**KIRKLEES METROPOLITAN COUNCIL
INVESTMENT & REGENERATION SERVICE**

Reference No:	2025/62/91744/E
Site Address:	42, Shirley Road, Gomersal, Cleckheaton, BD19 4ND
Description:	Erection of single and two storey extensions
Recommending Officer:	Edward Cheseldine

HOUSEHOLDER DELEGATED REPORT

PROPOSED ROOF PLAN
SCALE 1:50

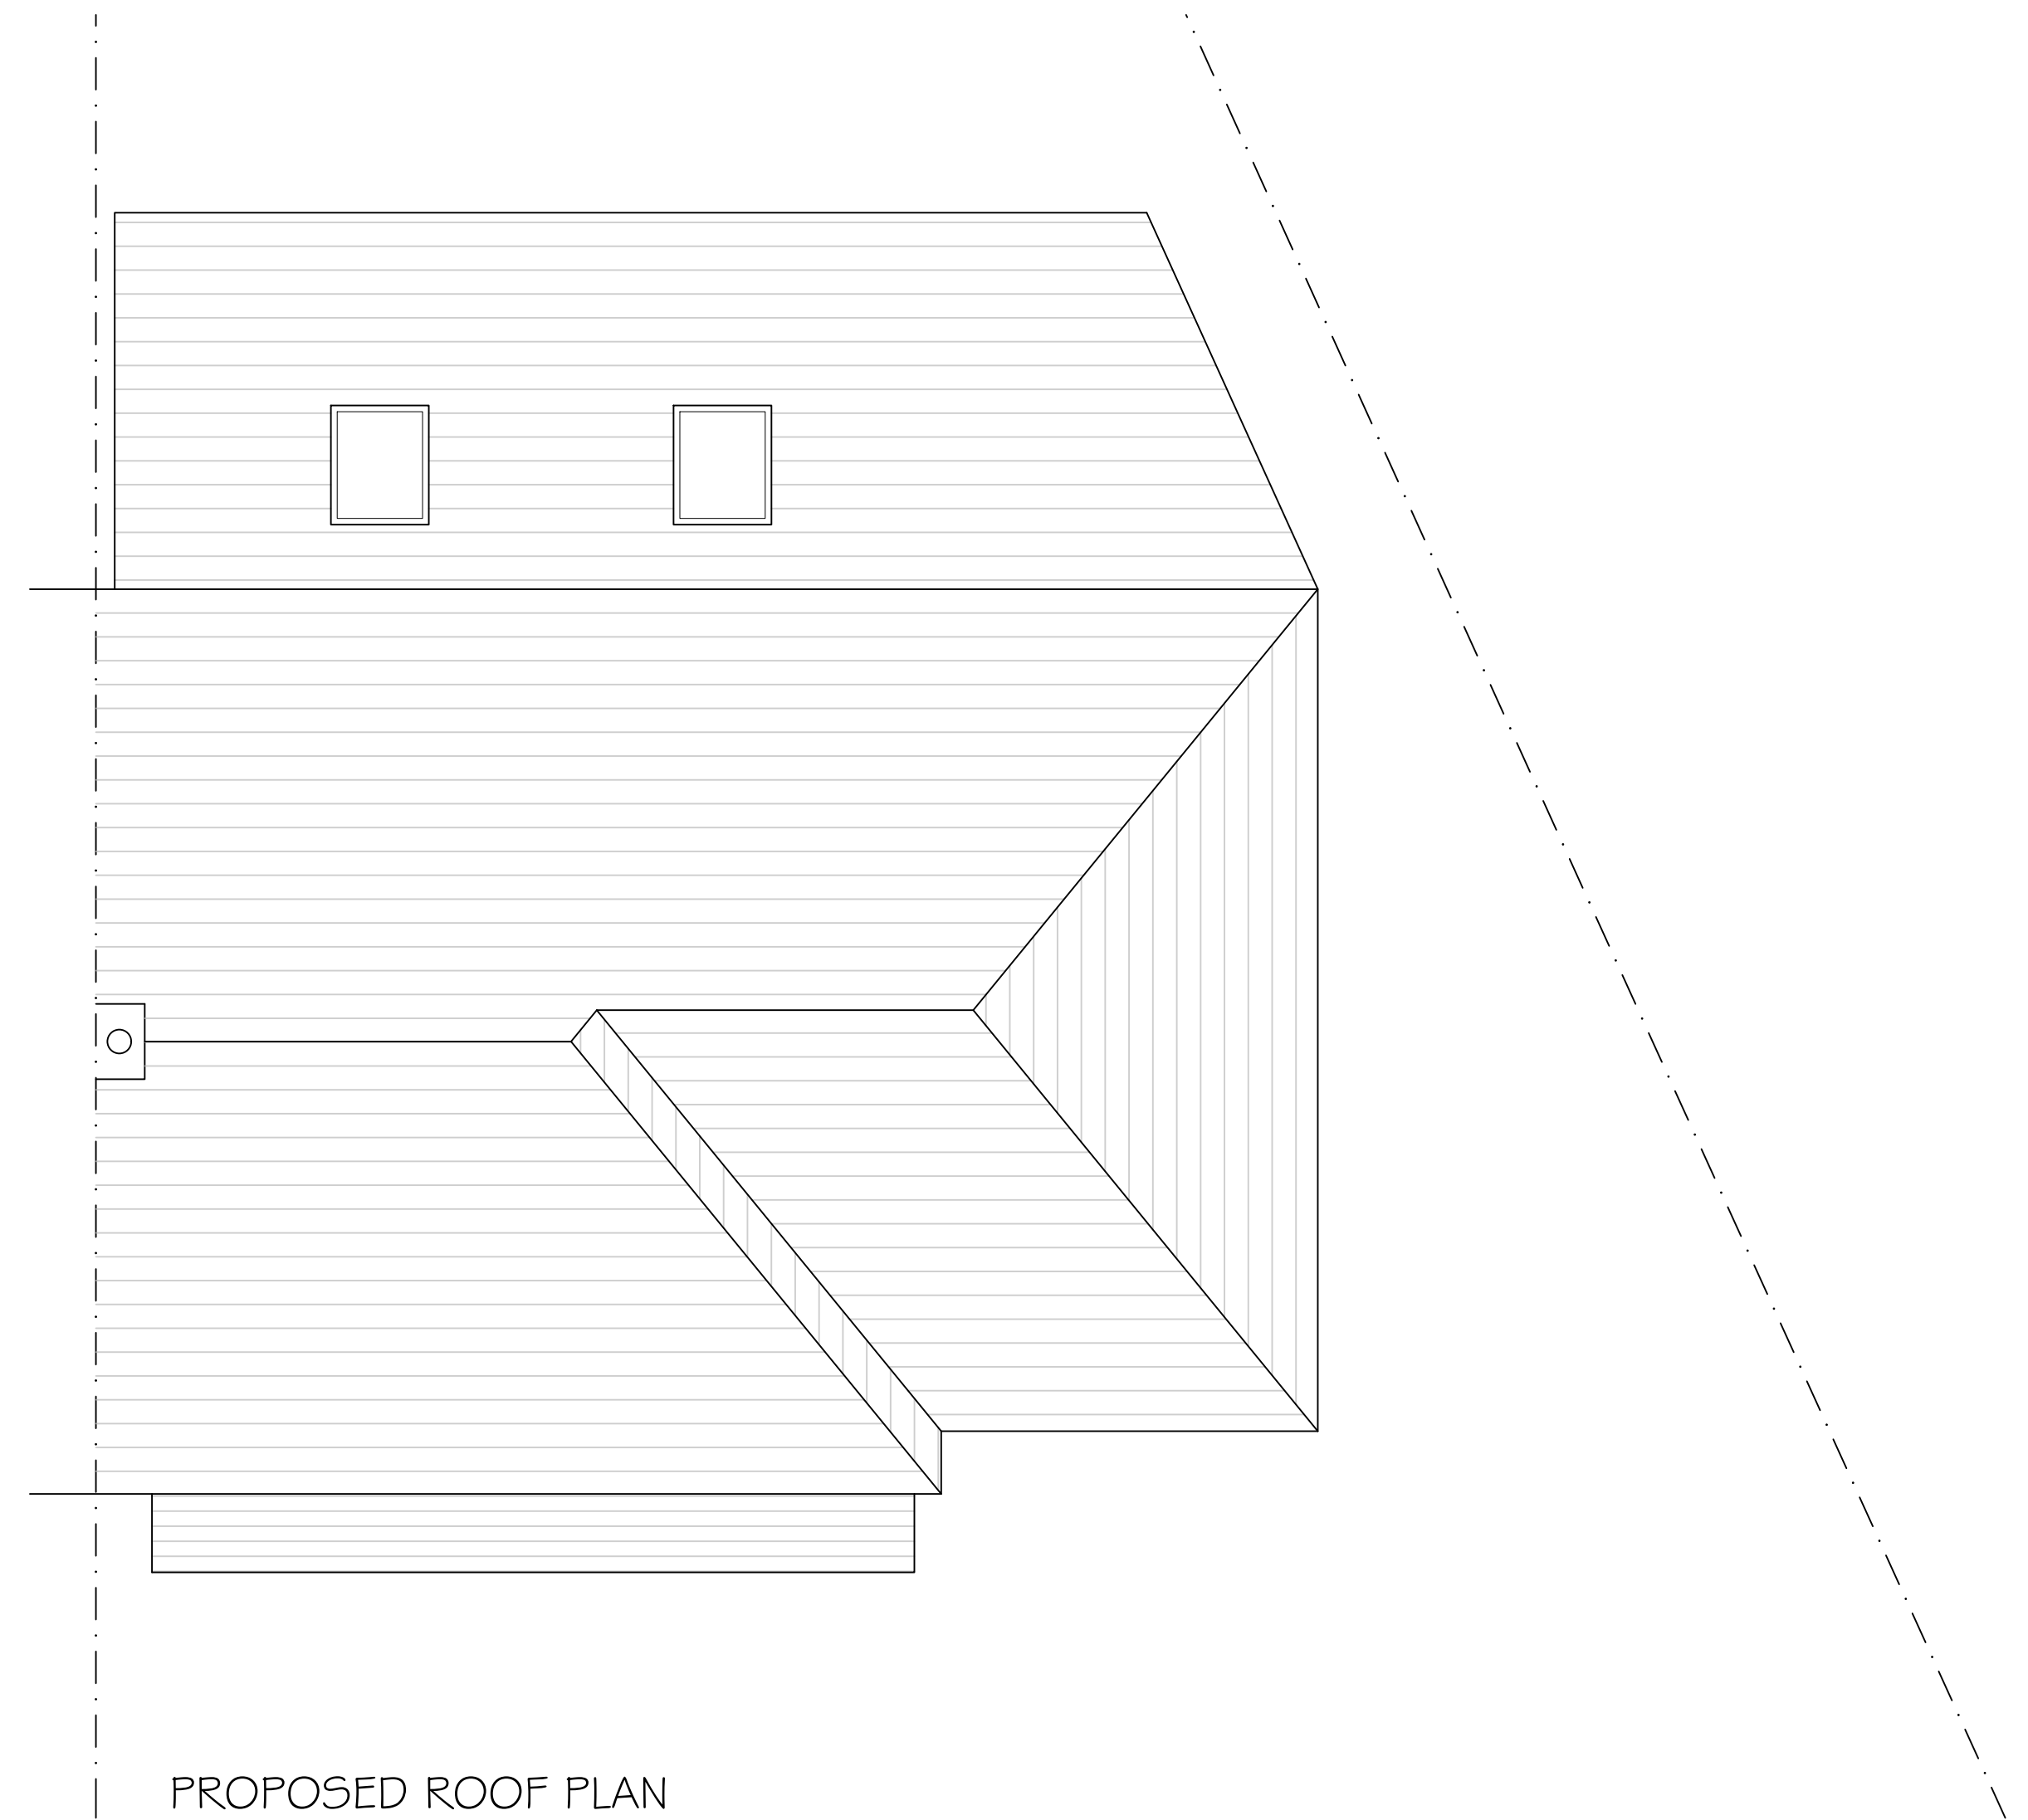
In addition, it was requested by Officers the hipped roof was retained. It was communicated to the agent a hip-to-gable extension would unbalance the pair of the semi-detached pair. An assessment of the existing surrounding building group was undertaken by Officers. This pair of dwellings would be the only pair in the local vicinity that would have unbalanced roof forms, therefore it was considered the weight of a building group with pitched and hipped forms was not as great as unbalancing the pair.

The applicant submitted amended plans to retain the hipped roof forms.
